**From:** system@affinitylive.com on behalf of Maureen Sidoti  
<maureen\_sidoti@hotmail.com>  
**Sent:** Friday, 18 December 2015 5:32 AM  
**To:** Ashley Cheong  
**Subject:** Submission Details for Maureen Sidoti (object)

My third submissions is an objection on the grounds of AMENITY, or more specifically the way in which the proposals outlined in this application would impact negatively on the pleasant and largely tranquil nature of the heritage environment of the Campbell's Cove foreshore, the Hickson Rd streetscape and daily life within that area as experienced by locals and visitors alike.

Site: #3103 Campbell's Stores

Drawing Title  
**ELEVATIONS**  
JPW Project Number  
12006  
Drawing Status  
EA  
Drawing Number  
EA-A-2000  
Revision  
B

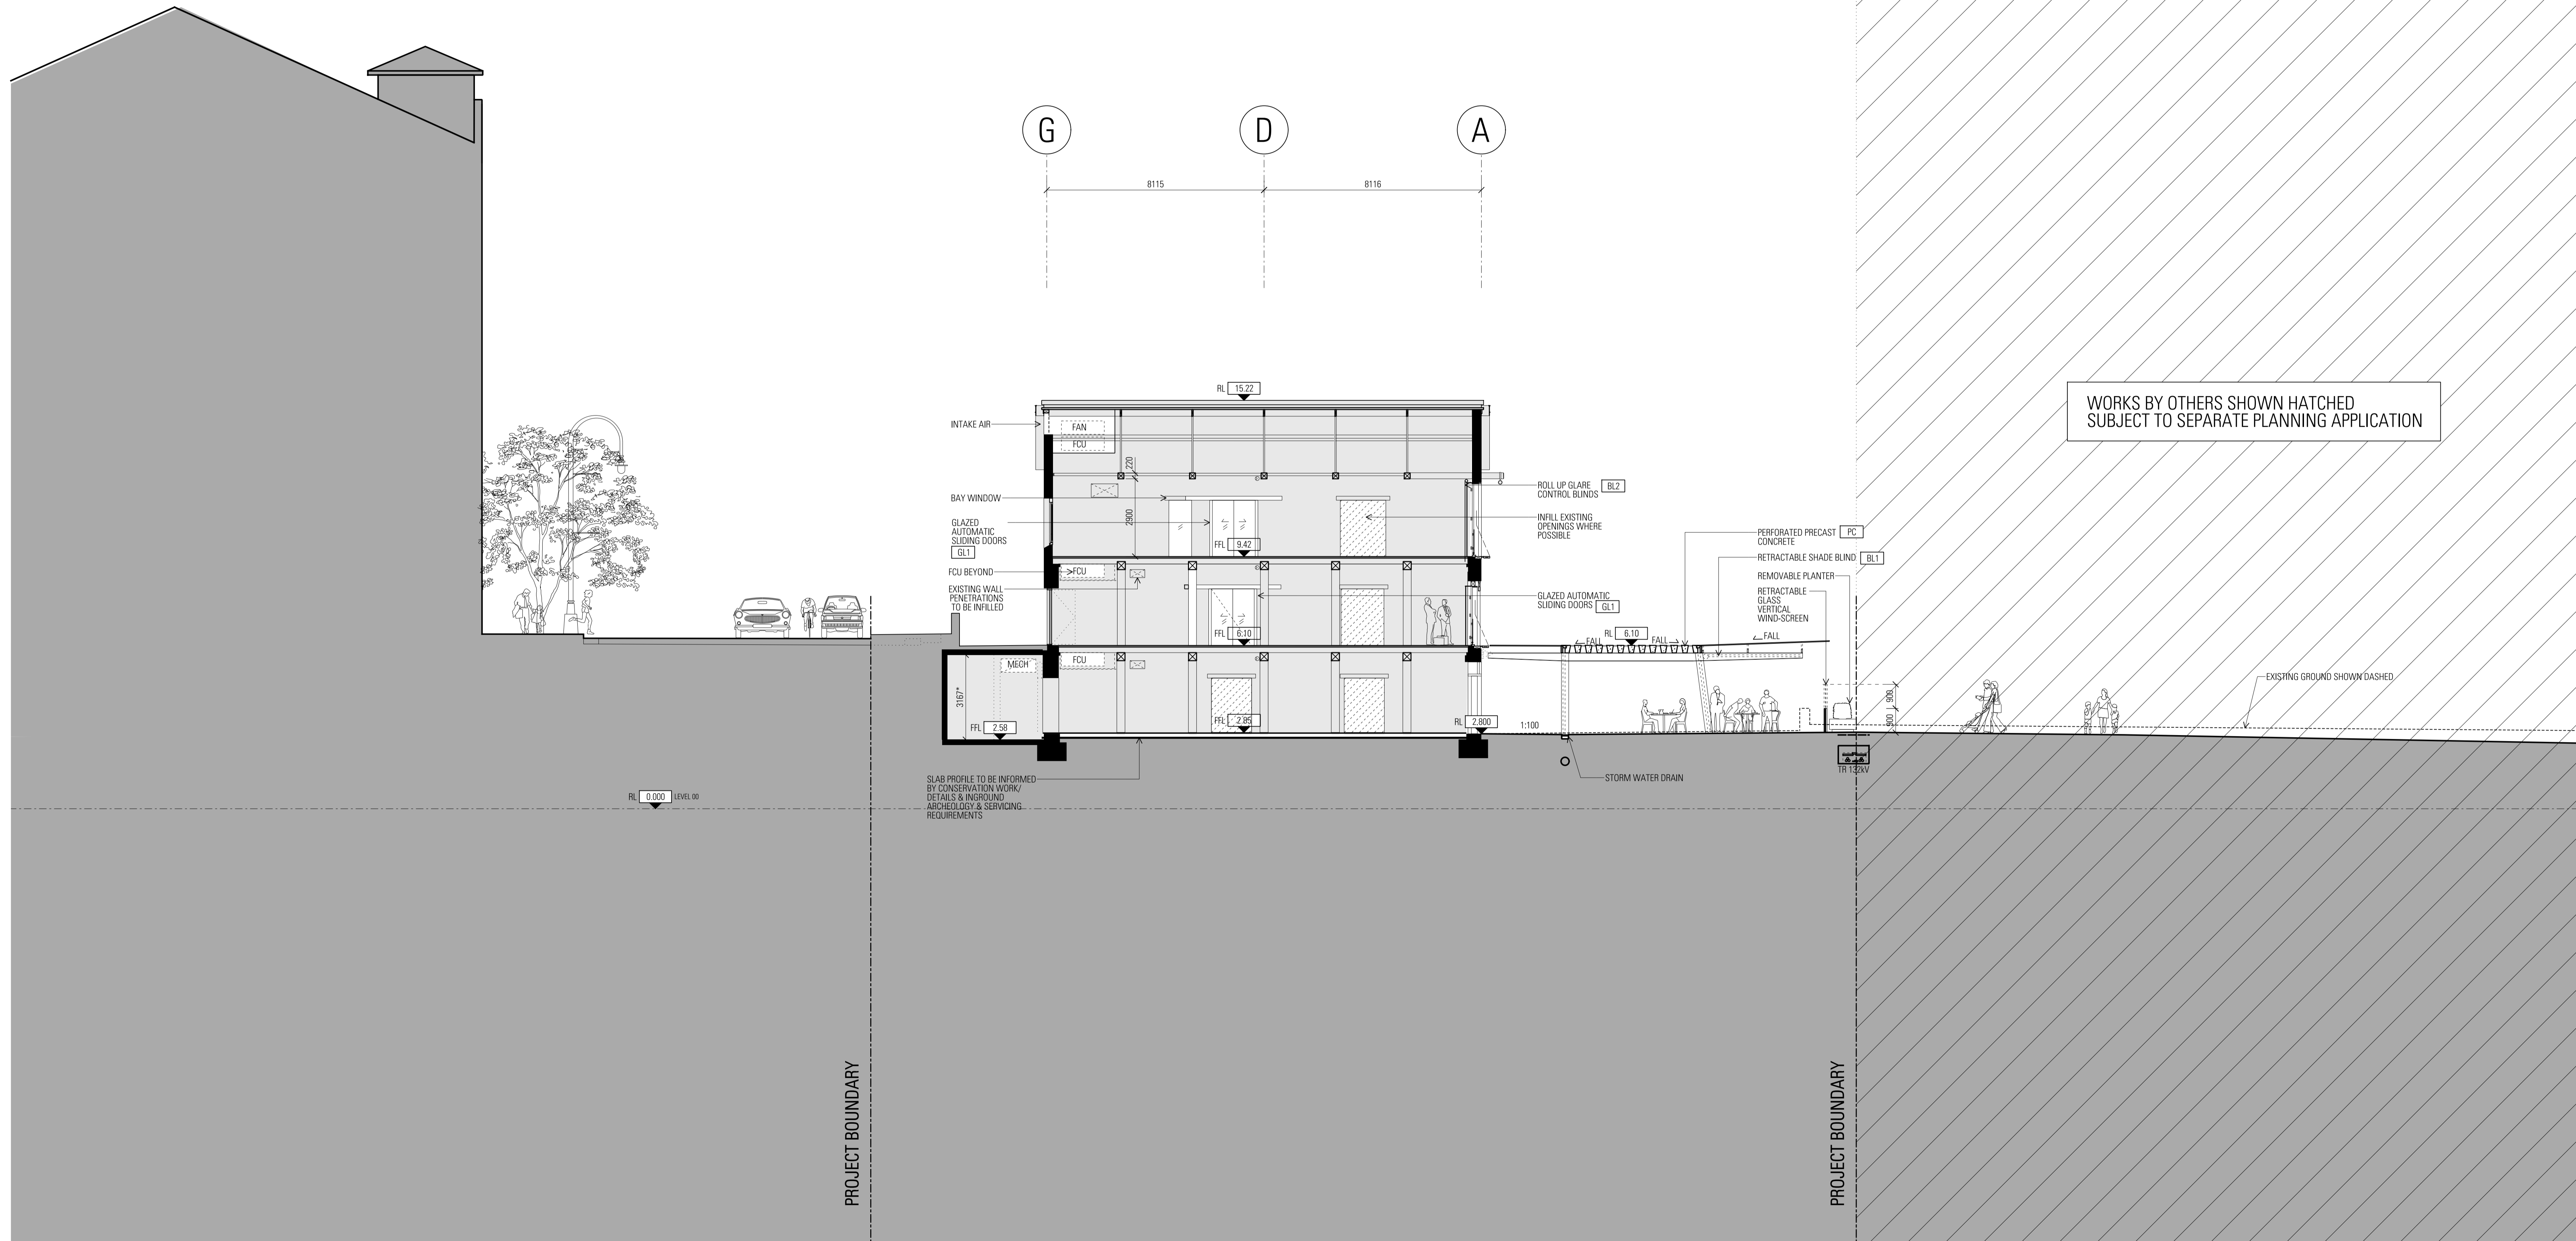
\* The Hickson Rd streetscape is one of largely heritage buildings from George St all the way to Towns Place. The glass box proposed for the northern side of Campbell's Stores would look as though someone had parachuted it in. It would have no visual or aesthetic relationship with the heritage building on one side of it or the sympathetic, modern lines of the Park Hyatt Hotel on the other.

\* The glass building would have the appearance of a tall and bulky glass box on stilts. It is the worst of the applicant's proposals and would substantially contradict the heritage environment of Hickson Rd and the Campbell's Cove foreshore.

\* When measured from a new raised ground level, the glass box would be 13.3 metres high with the inclusion of its 1 metre high lift overrun. This exceeds the current height restriction on the foreshore frontage by 14.5m, i.e. by more than 250% and on the Hickson Road elevation by 10.5m, or 140%. It would be a full storey higher than Campbells' Stores' gutter with the lift overrun making it higher again. (Design Statement diagram p.96). It would be higher than the Park Hyatt Hotel alongside it. Building plans suggest that the way has been left open for further expansion in the future.

\* Given this height and bulk, the proposed new four-storey glass box would dwarf the heritage-listed Stores, dominate the Campbell's Cove foreshore and be the tallest building on this side of the Hickson Rd streetscape.

\* Currently, when walking south along Hickson Rd, we can see the upper two storeys of Campbell's Stores' northern end. The box would hide the entire building and 'bury' its ground floor under a new, nearly 2 metre higher, ground level so as to accommodate a basement area for the glass box.

\* The glass building's minimal 2.5 metre undercroft would feel oppressive and tunnel-like. This, along with its intended use as an outdoor eating area, would serve as a barrier that locals and visitors would have to pass through before any views of the Opera house would emerge. As someone said recently, this 2.5 metre high undercroft would make existing views of the Opera House seem like 'looking at it through the slit of a letter box'.
